Our ref: DOC22/1006503

Sender's ref: SSD-5684-Mod-2

Subject: Request for agency advice – Bringelly Quarry/Brickworks (Mod 2) - Extraction and production increases (SSD-5684-Mod-2)

Figure 2 – Plan of existing and proposed development

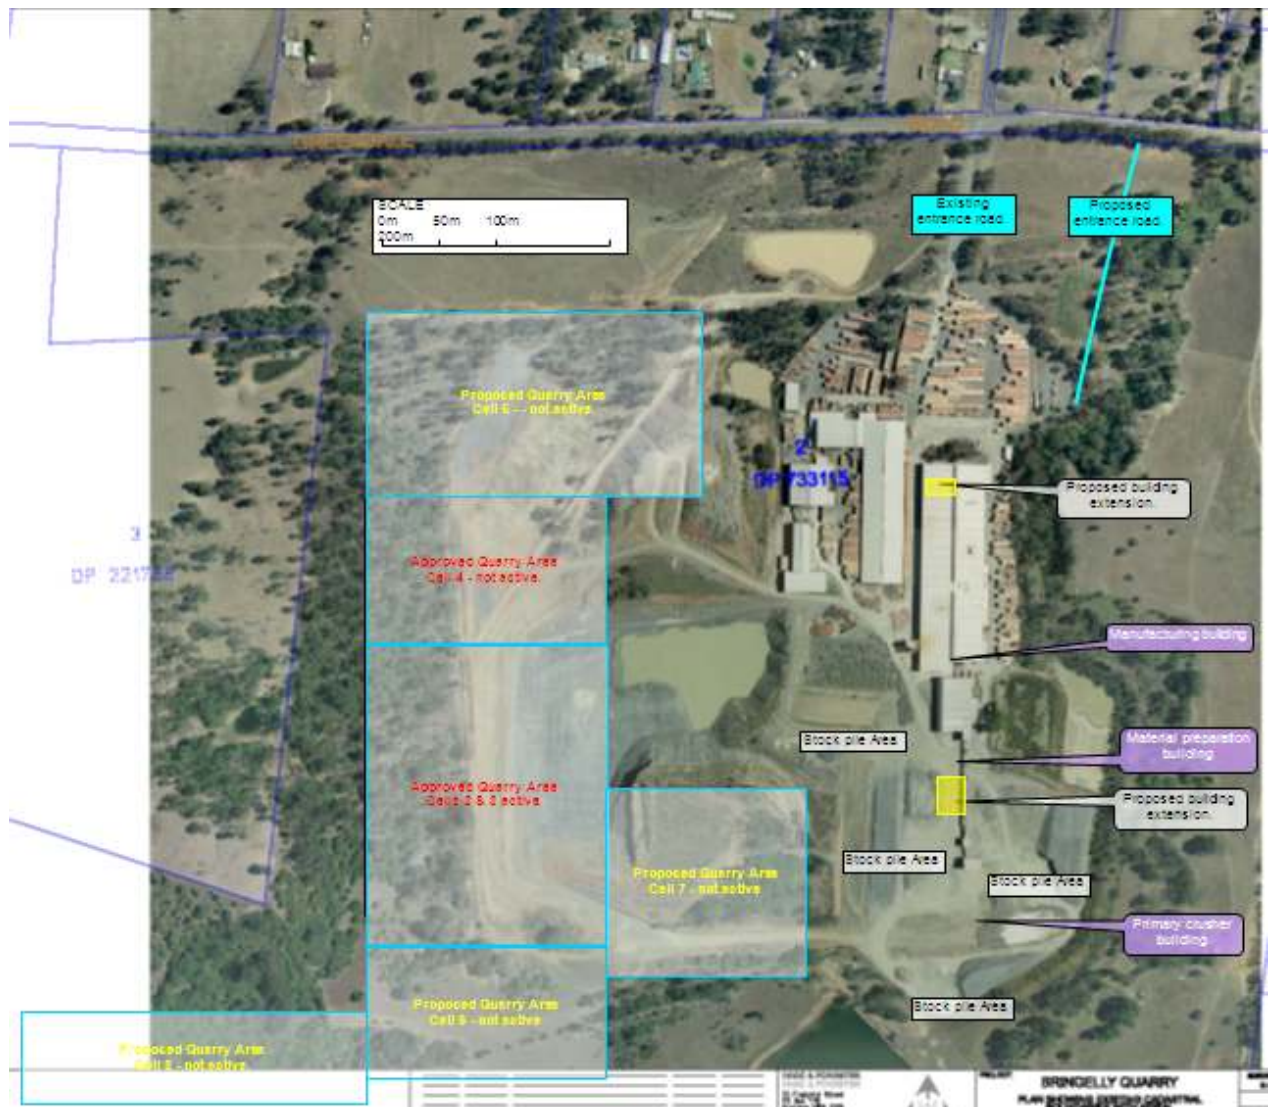
EHG considers that the applicant should provide information whether any of the proposed modifications (as depicted in Figure 3.2 of the Modification Report) are impacted by the PMF flood events. If so, EHG would recommend that a site emergency response plan is prepared in consultation with the NSW State Emergency Service to ensure the safety of the users of the site.
